From: Finlay Gardner
Sent: 04 September 2019 16:17
To: Planning.Responses <Planning.Responses@arun.gov.uk>
Subject: FW: Application BR/178/19/PL

I have recently taken over your application BR/178/19/PL (Delawarr House, Flat 1). I am emailing with a few questions about the proposed plans. In the larger flat the bedroom appears to not have any direct access to daylight. Would there be a possibility of a window in the dressing room? Any information you can give me will be greatly appreciated.

PROPOSED FIRST FLOOR PLAN/ROOF PLAN
Scale 1:50

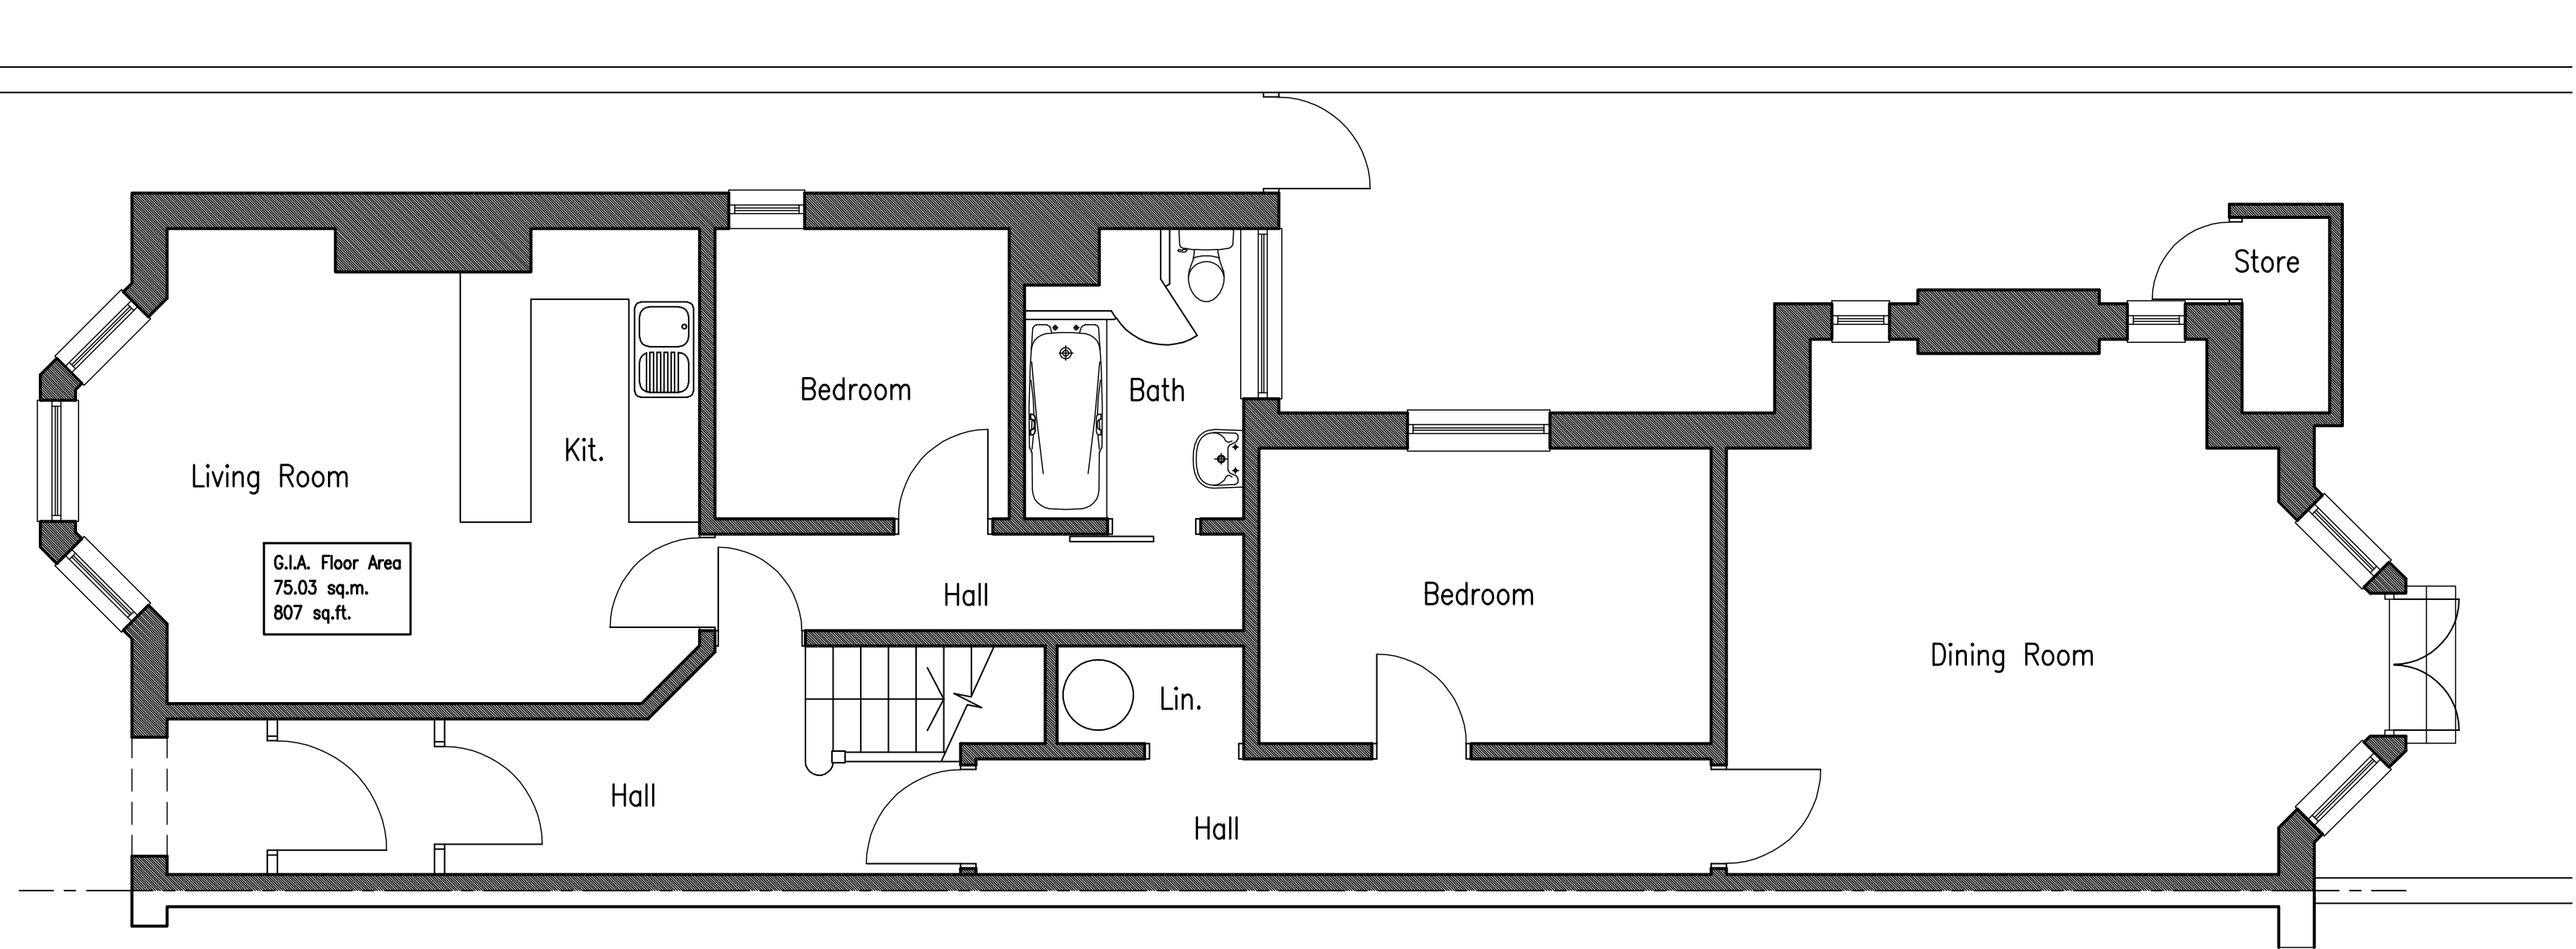
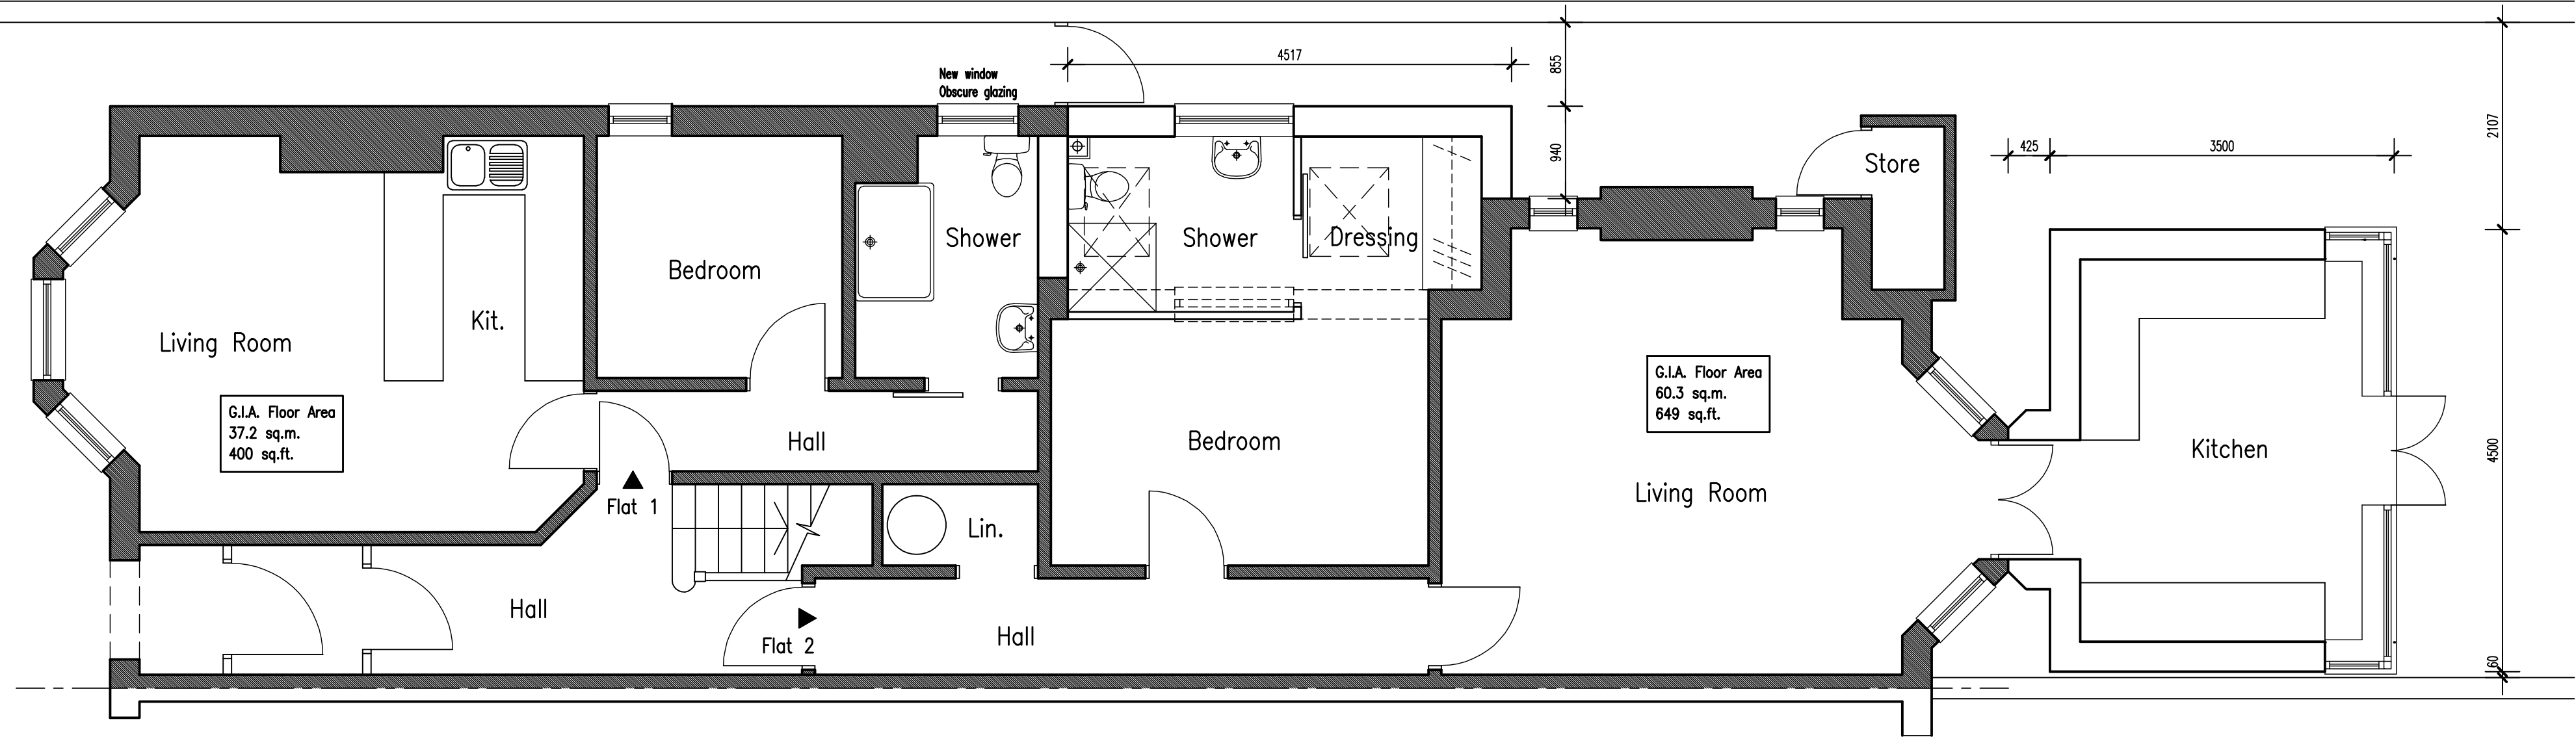
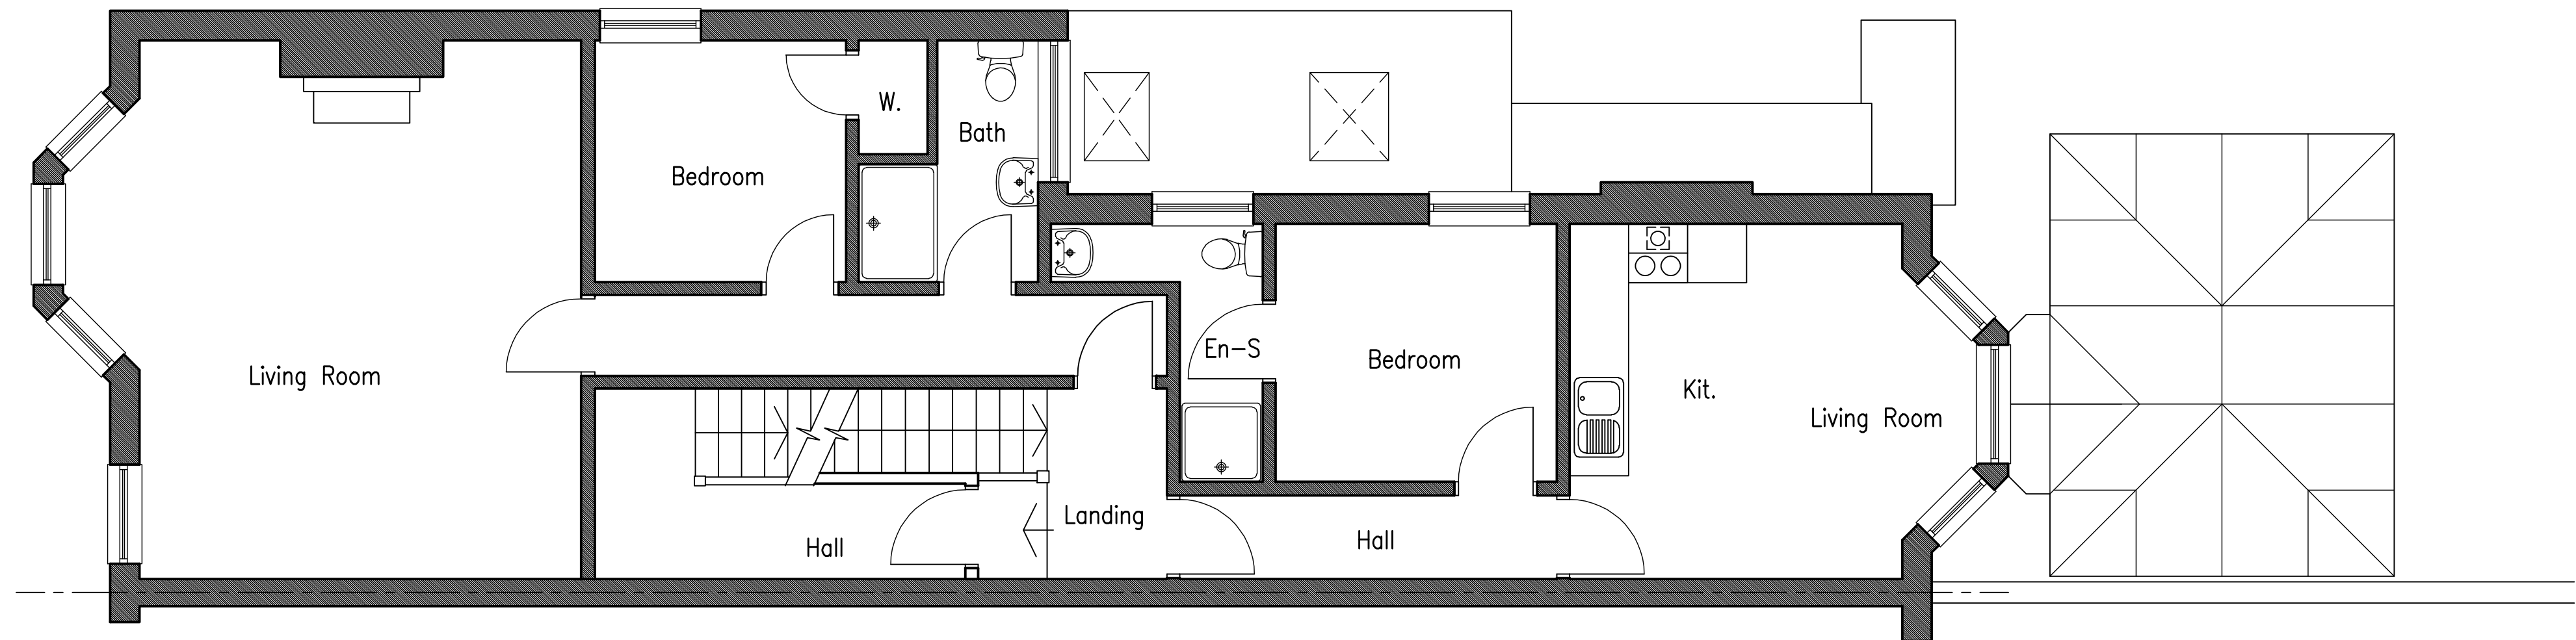
The issue that we find with the sky light is that it is not direct light into the bedroom, the way we would see to overcome this is to have a window in the dressing room, is this a possibility?

Further to your earlier e-mail please find attached amended planning drawings showing an additional window to the side extension bedroom as requested.

Further to your e-mail below I can confirm that the plans currently show a roof light to dressing room. I have attached the floor plans and elevations for your information.
